From: [REDACTED]
Sent: 12 January 2023 14:06
To: Planning
Subject: FAO Kathryn Hughes. Moran's farm chalets.

Please accept this email as a formal complaint about the revised drawings at Moran's farm chalets.

Drawing:
site layout & landscaping

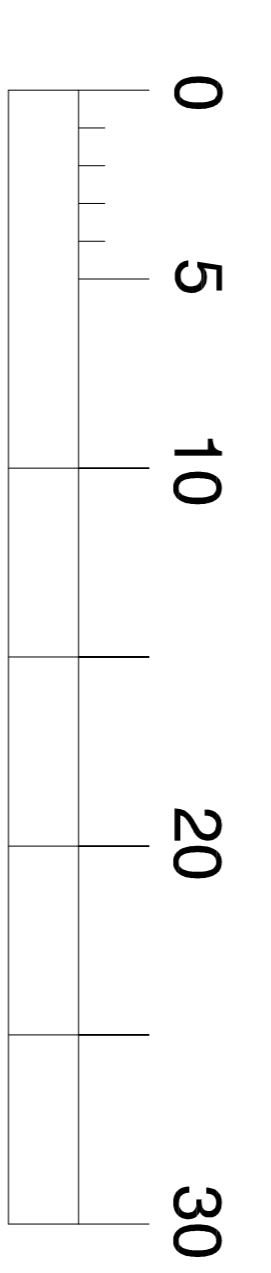
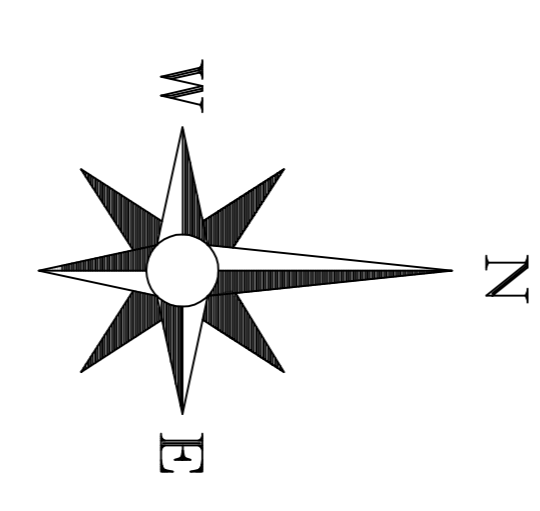
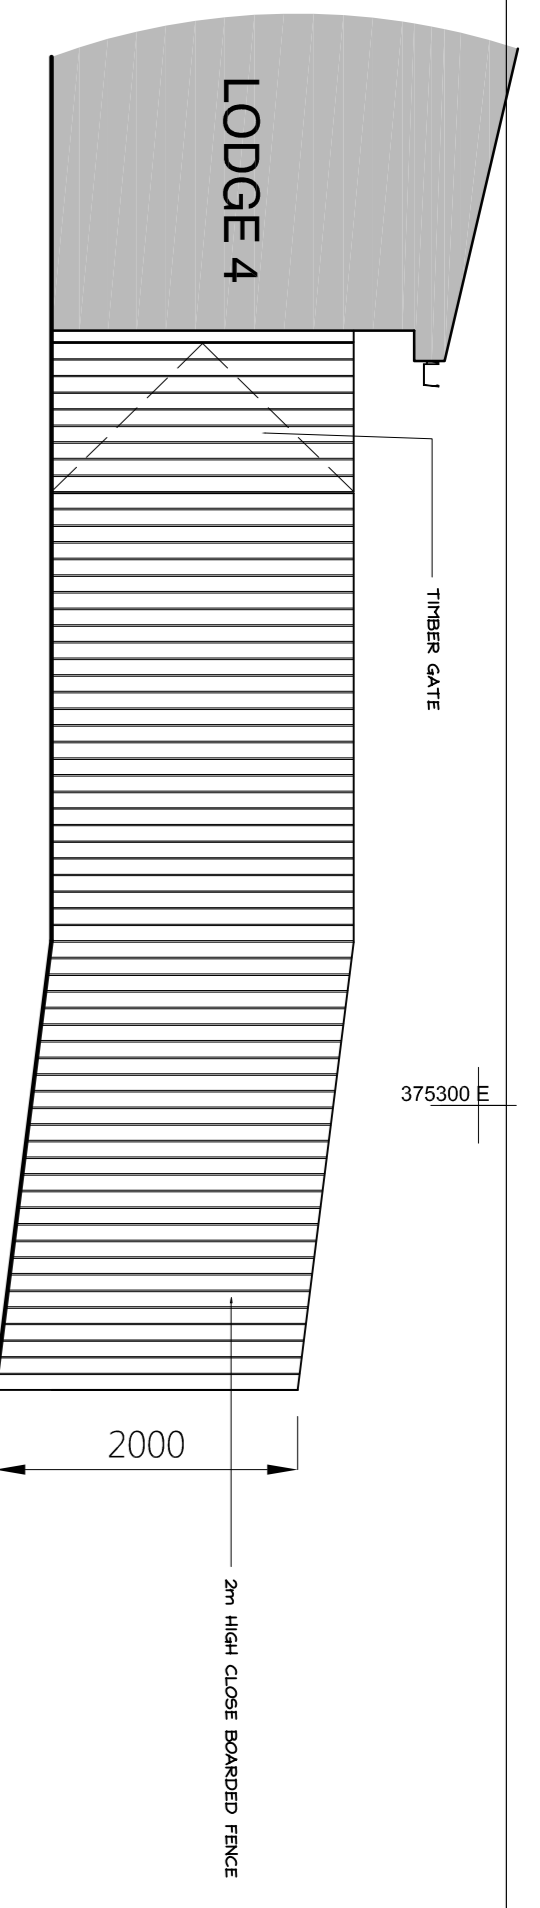
The added hedges on the amended site layouts have no heights.

For this reason we object to this variation order. If the council choose to accept this route, we must insist on a minimum 20' height conifers (easily purchased from commercial nurseries) and a timescale of no less than 20 years.
